# V1\_Drainage Report - Final\_Comments.pdf Markup Summary

PCD File No. SF-2239

ON-SITE BASINS
1"=100'

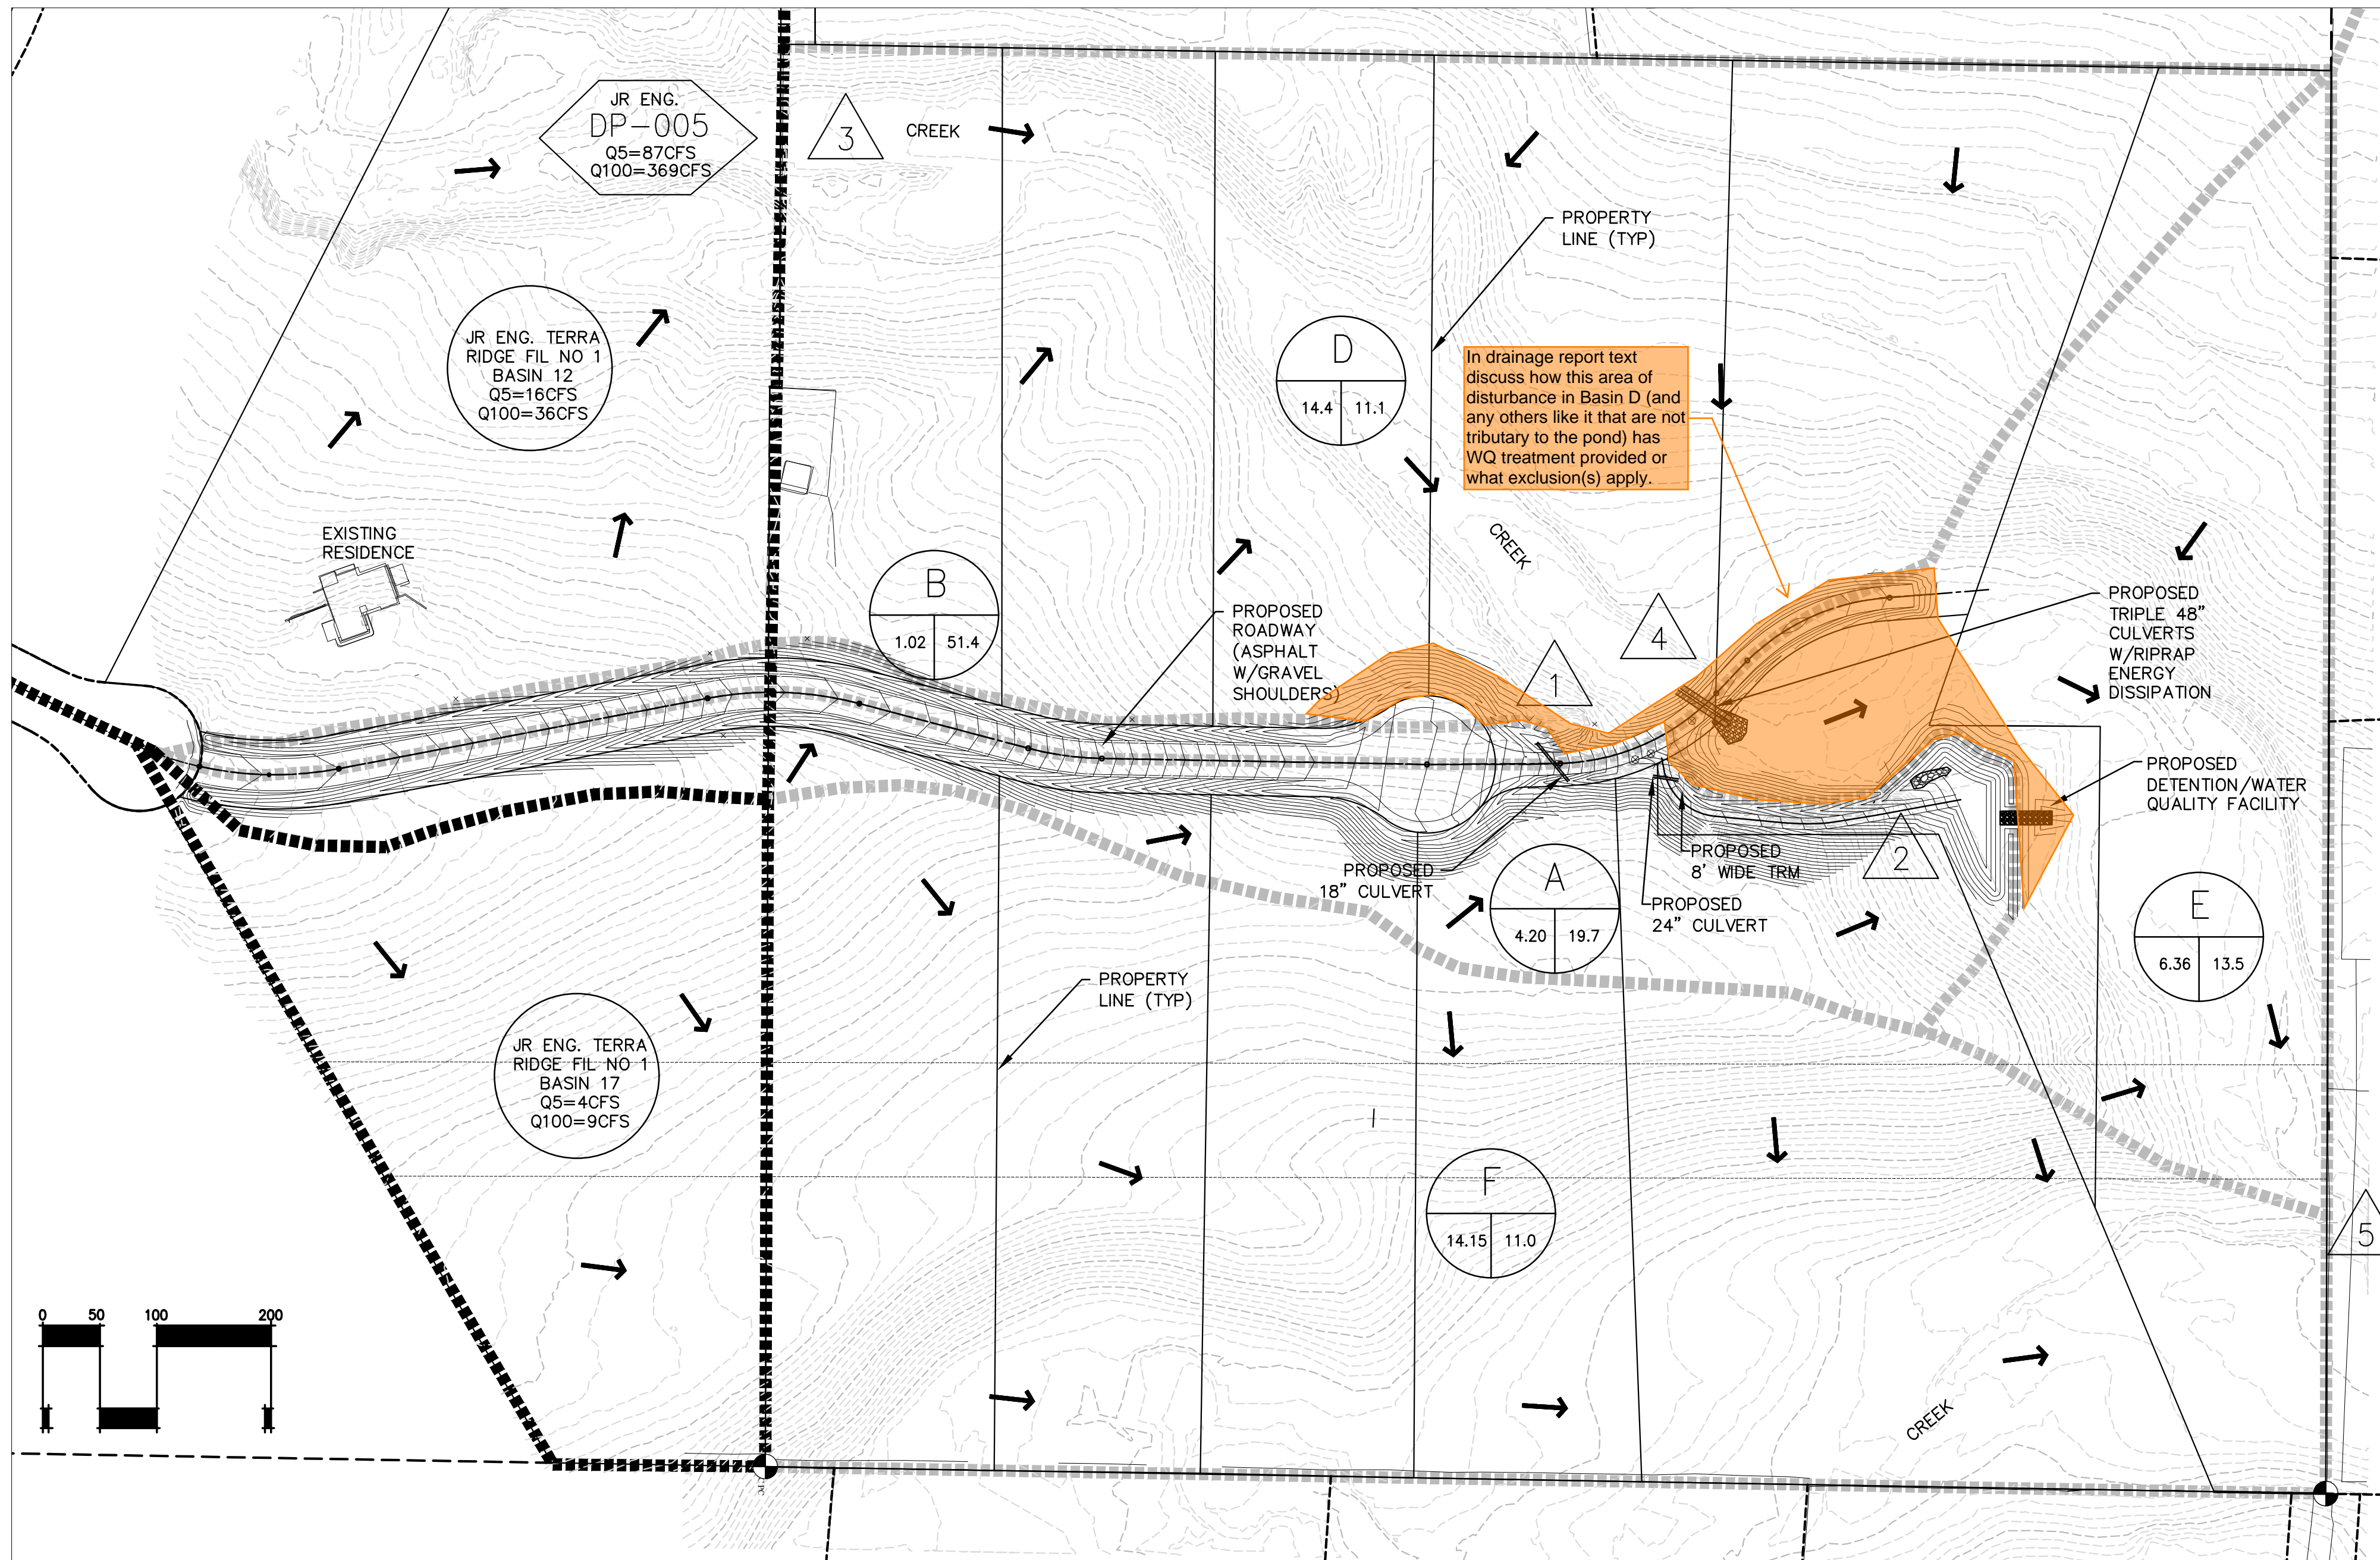
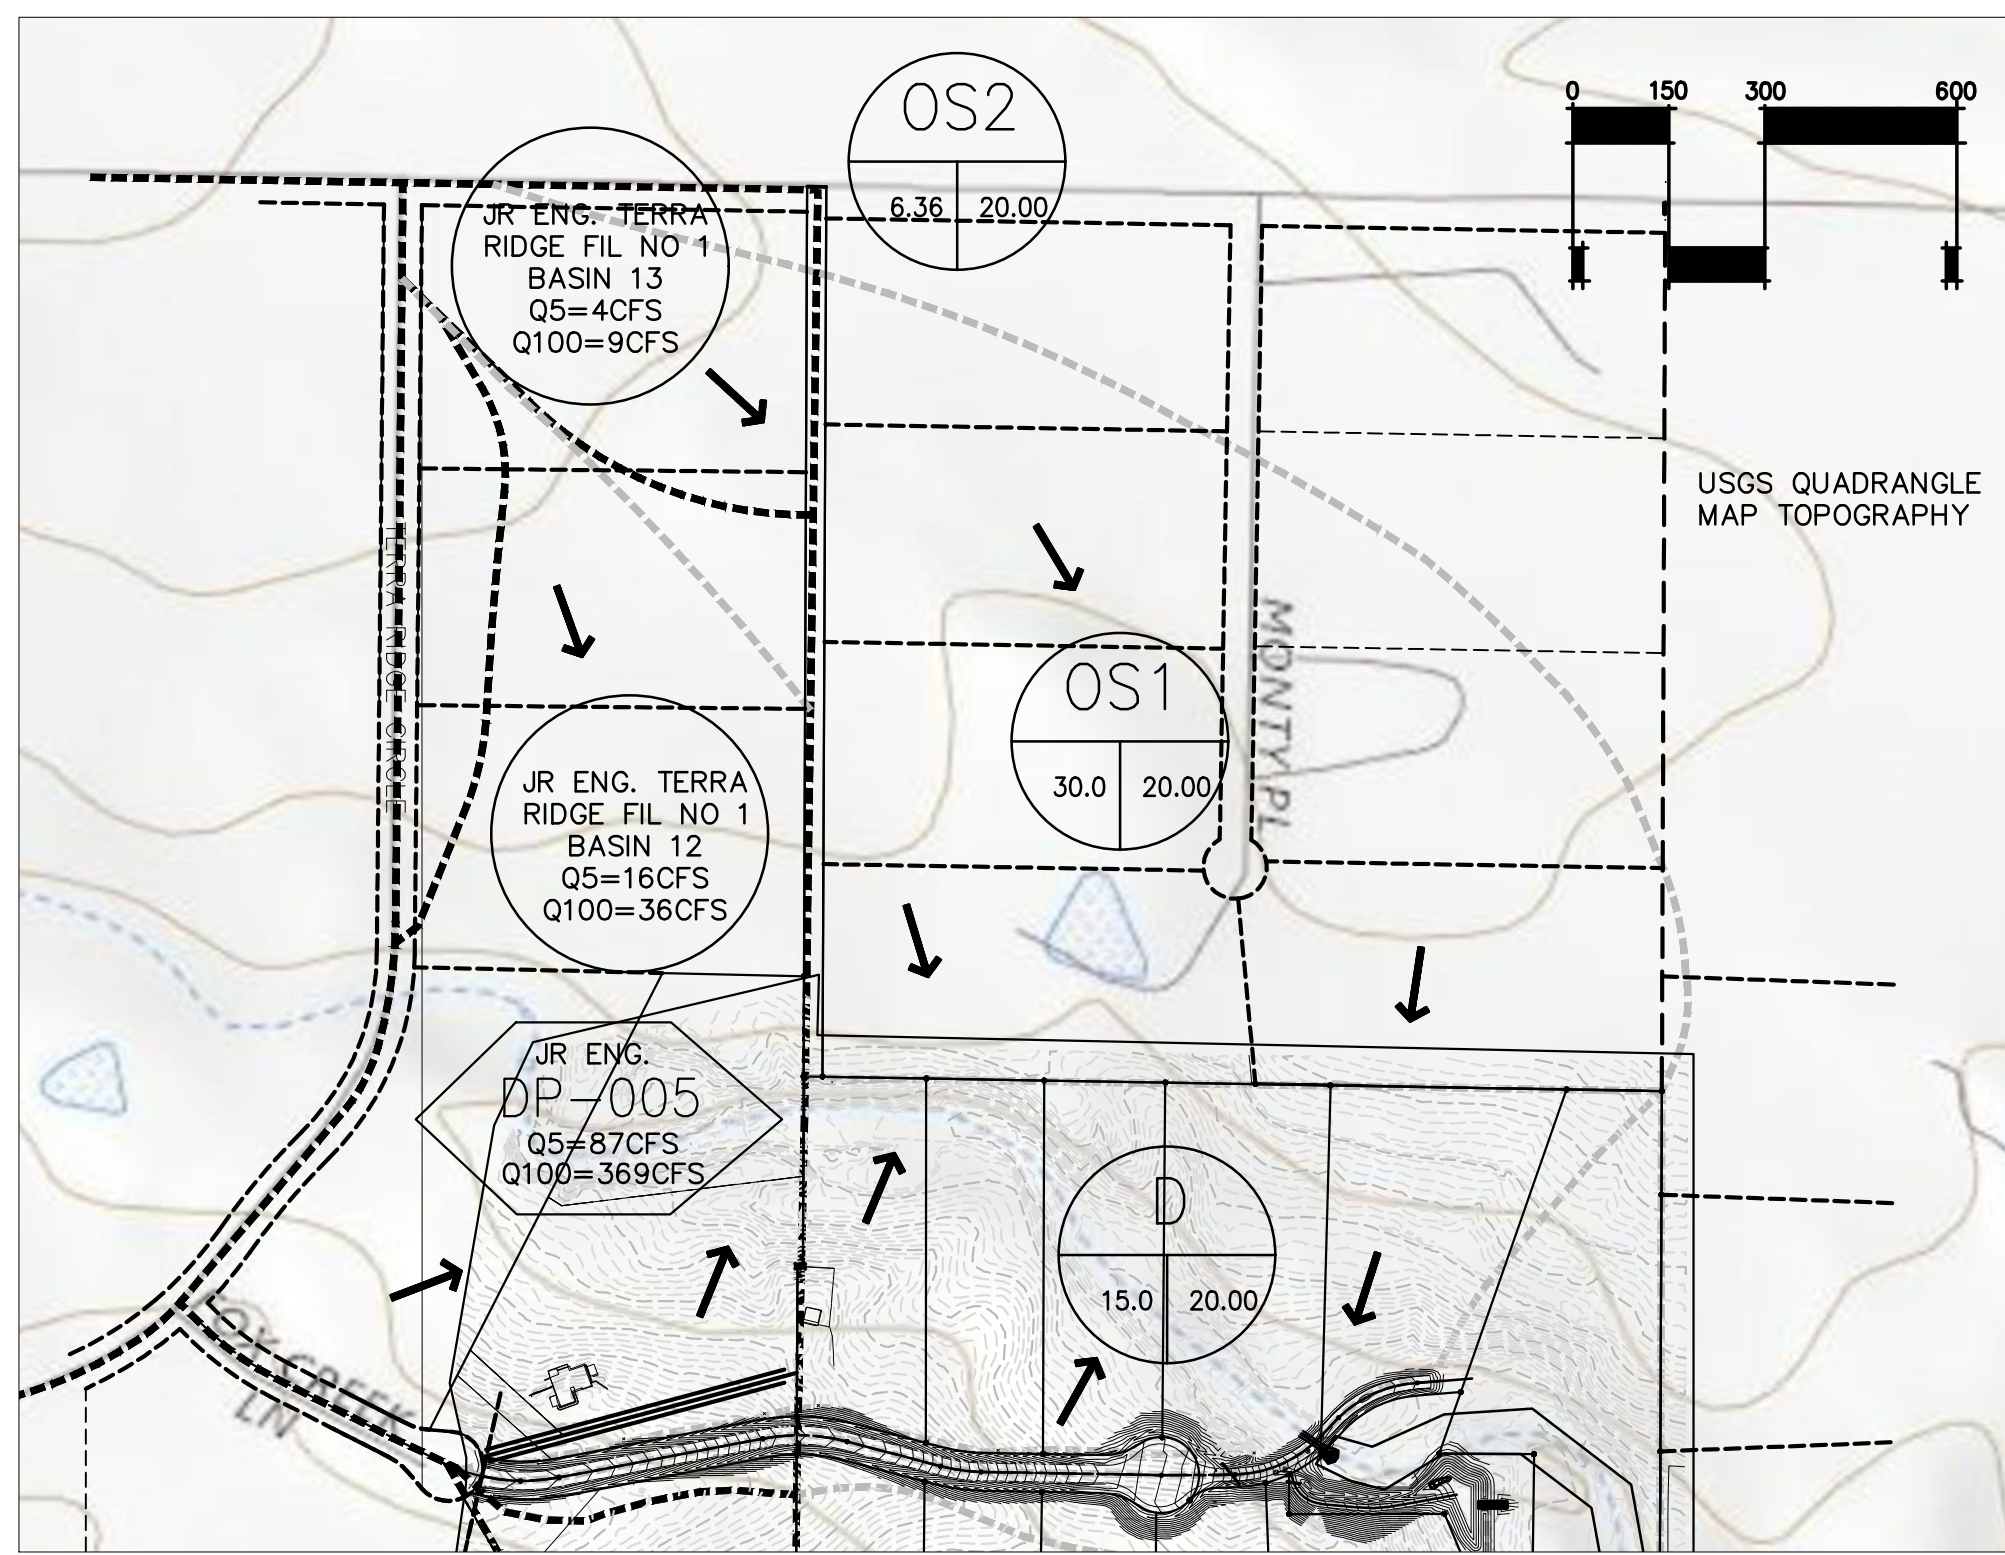
provide Hec-RAS channel hydraulic analysis to determine if improvements such as bank armoring at the bends are required.

Two culverts are addressed in the previous narrative. Revise to remove inconsistencies. Also remove culvert analysis reports for culverts that are not being proposed.

Add a column that identifies the contributing basins and design point for the cumulative flows.

provide outlet protection calculation to the 24" and 18" RCP. Update the CDs if outlet protection is required.

Add dark linestyle to legend. If it is just delineating basins keep linestyle consistent.

Label entrance types on culverts per culvert reports attached.

Provide a detail for the spillway that shows cross section.

Show time of concentration paths on drainage maps.

Provide contour labels.
